Report following a request for further information, negotiations or consultation

REF NO: BR/194/17/PL

LOCATION: Promenade Opposite Walton Avenue
The Esplanade
Bognor Regis

PROPOSAL: Demolition of the existing Foreshore office & decommissioning of existing underground toilets. New purpose built unisex toilet block including urinals, baby changing facilities & accessible WC, plus a separate beach office with public information point & first aid facilities. All located on the existing seafront promenade.

Proposed Elevation South
1 : 50

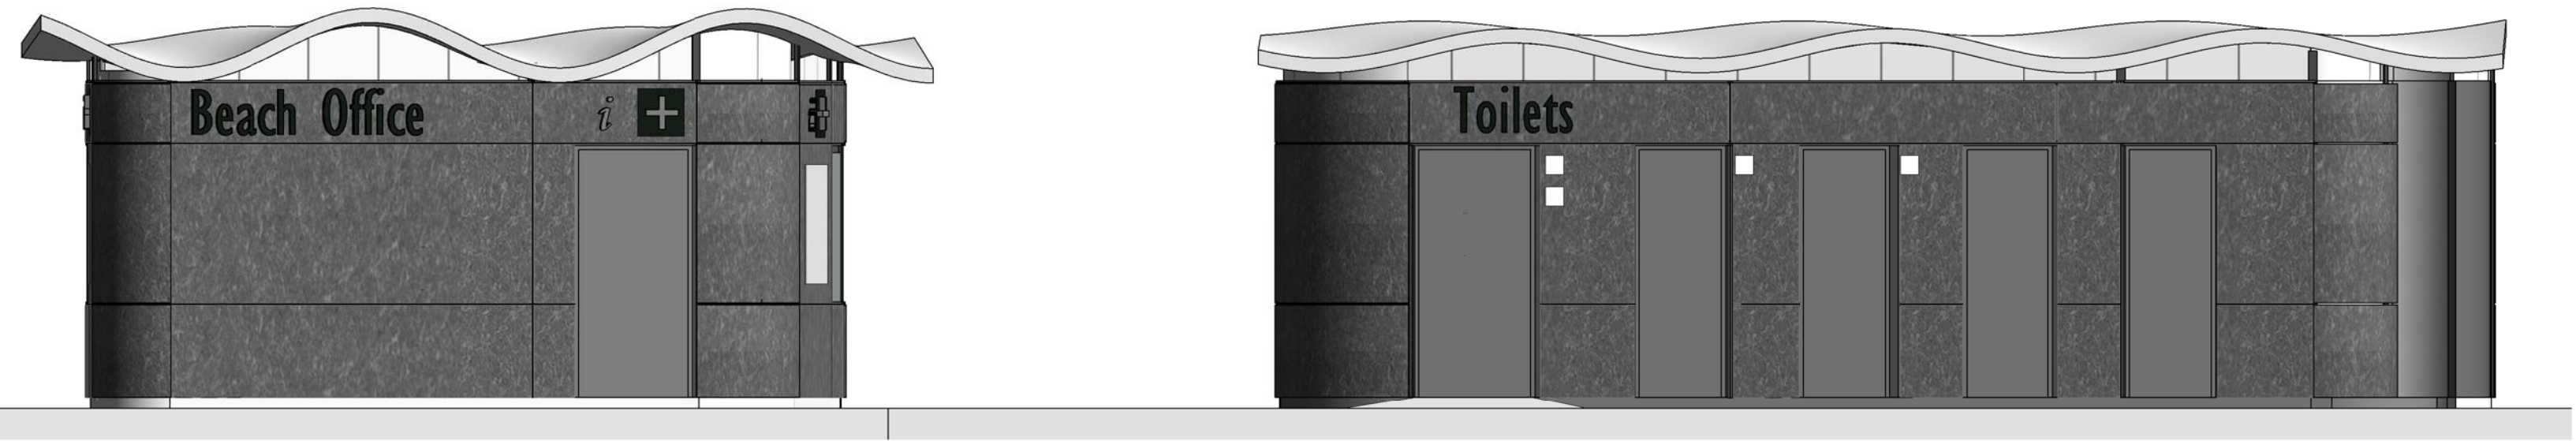
Sussex Police Designing Out Crime Officer has suggested a guard rail to one side of both rear staff entrance doors so the public are not hit by the doors opening outwards.

- Main toilet signs too large and damaging to outlook of properties on The Esplanade. Toilets are not for passing drivers
- The reason for the new toilets on safety and crime grounds is unfounded
- Fall back position regarding the building being able to be constructed under permitted development is not relevant unless there is a realistic prospect of the building being carried out under permitted development.
- Removal of clerestory glazing makes the building not sustainable development.
- The design is out of context with the area.
- The development is not in compliance with Bognor Regis NDP policy 8a

It is not considered reasonable to require guard rails for the rear doors as they will not be used often and it is unlikely the public will be walking behind the two buildings.

The toilet signs are not considered to be overly large with approximately 45cm high for the largest text letters. Furthermore, they are to be individual letters in a thin font applied to the walls of the buildings which are not overly loud or garish. The toilets are public toilets so are open for use by anyone, including passing drivers.

South Elevation

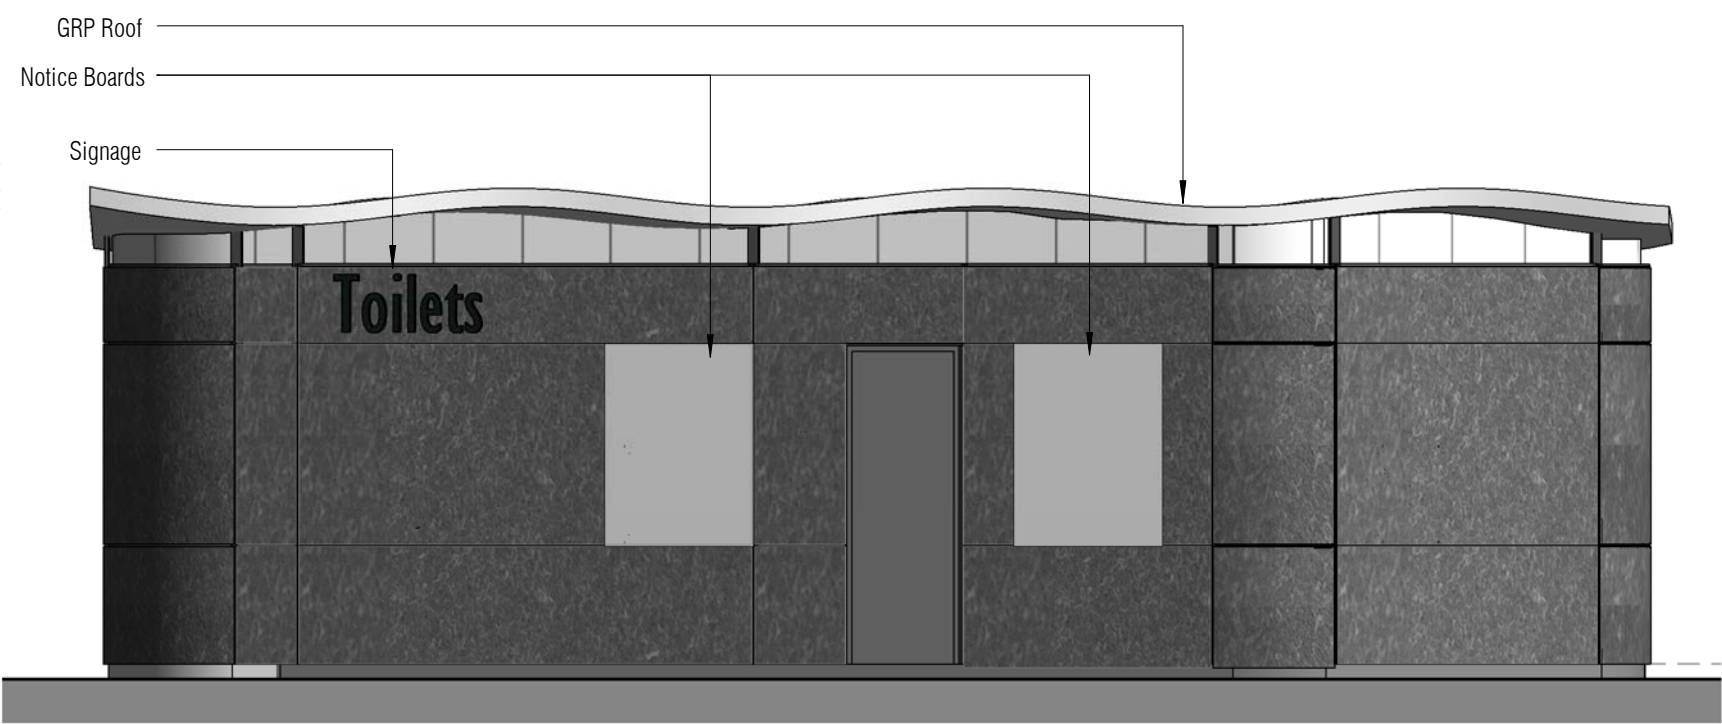
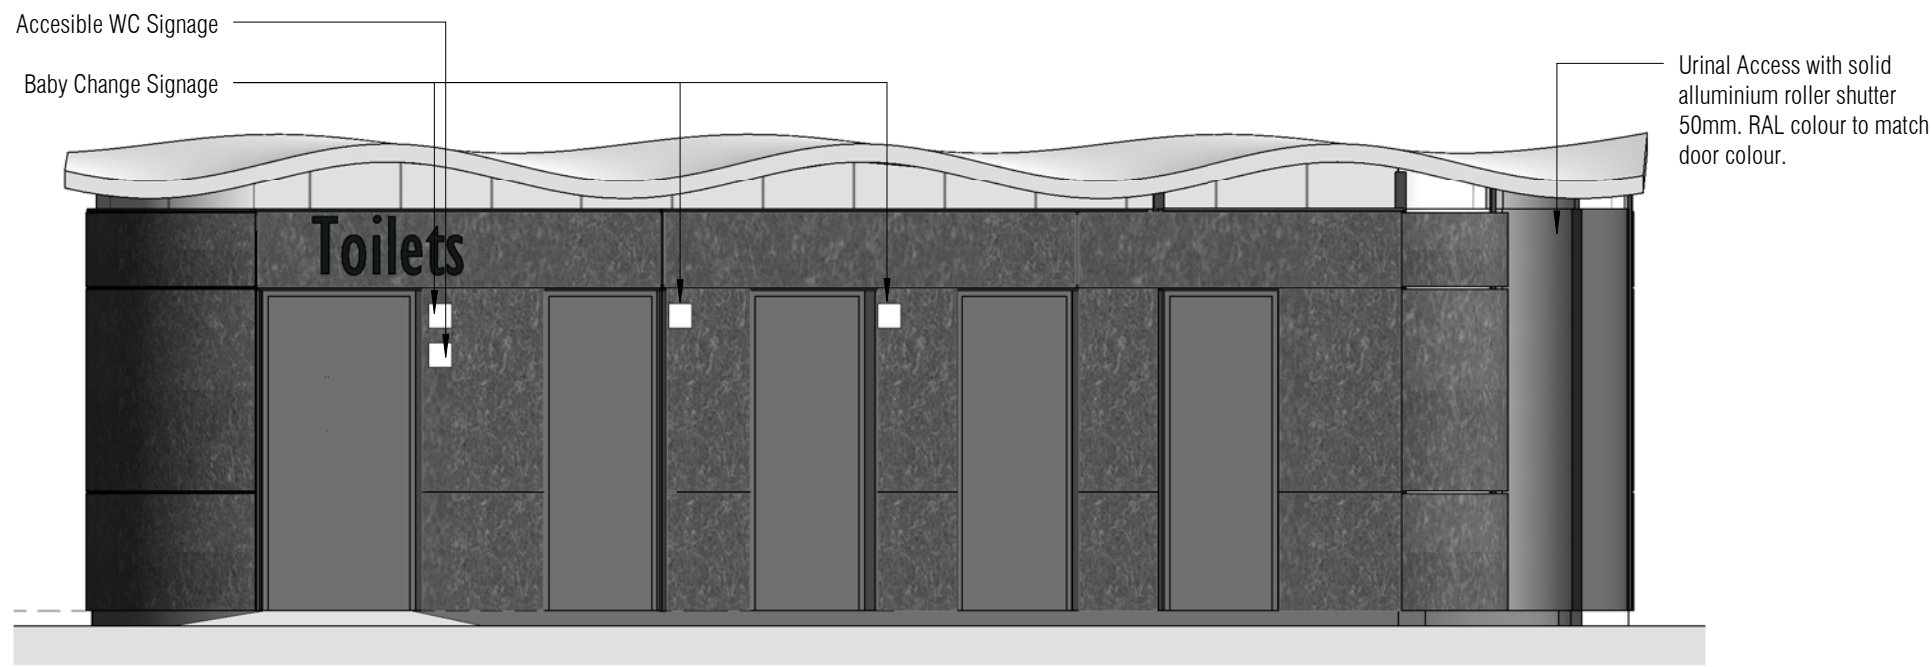
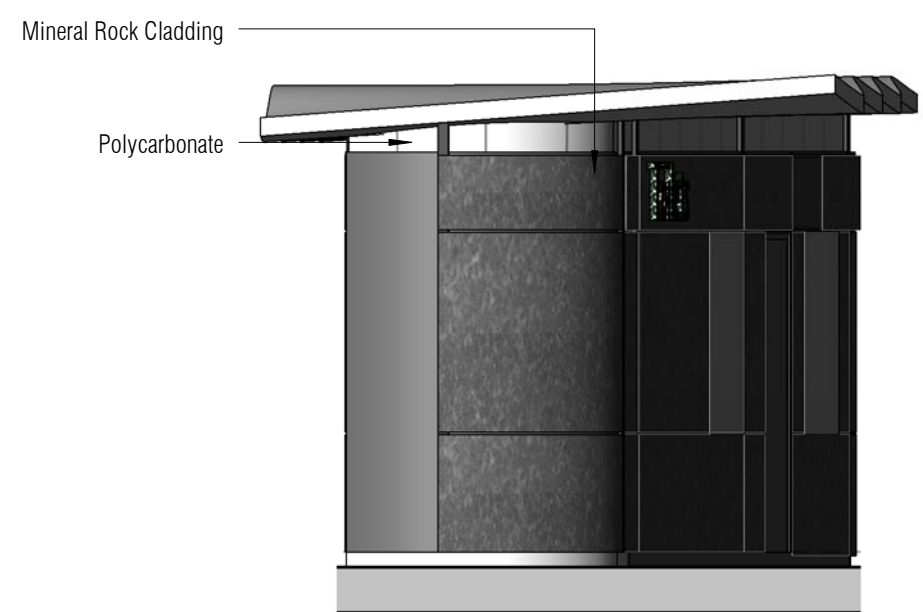
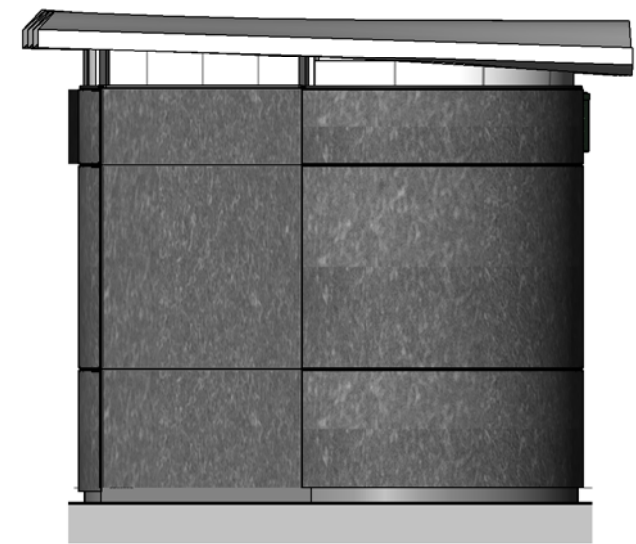
- I have concerns about the positioning of the facility, which as result causes the toilets doors to open onto the promenade's balustrade area. With the doors open, this creates a barrier blocking users in, unable to make their way back to the promenade until the adjacent door is closed. This is more apparent for the middle cubicle users

- Despite the design's orientation being suggested to alleviate bad weather conditions impacting upon the users, I recommend that the orientation be changed so that the doors open onto the promenade. This will remove the possibility of creating a blocked off area and reduce the opportunity for robbery and assault as well as reducing the fear of crime by utilising natural surveillance and the presence of capable guardians who are using the public promenade.

- I question why one cubicle door opens in, when the others open out. This reduces considerably the space within, given it is a baby cubicle, this may impede upon the size of pram / pushchair used and create problems shutting the door.

- i) The toilet doors facing south (towards the beach)
- ii) A screen in front of the urinal entrance
- iii) The buildings have been moved further north
- iv) Two guard rails have been sited to the south elevation either side of the entrances.

The toilet doors now face the beach following a reorientation of the toilet building. There is also to be a screen to the north of the entrance of the urinals section. This would be approximately 2.1m high and curved to cover the entrance and made of a solid material as to not allow vision through. As such, concerns of residents of overlooking from persons exiting the toilet are considered to be addressed.
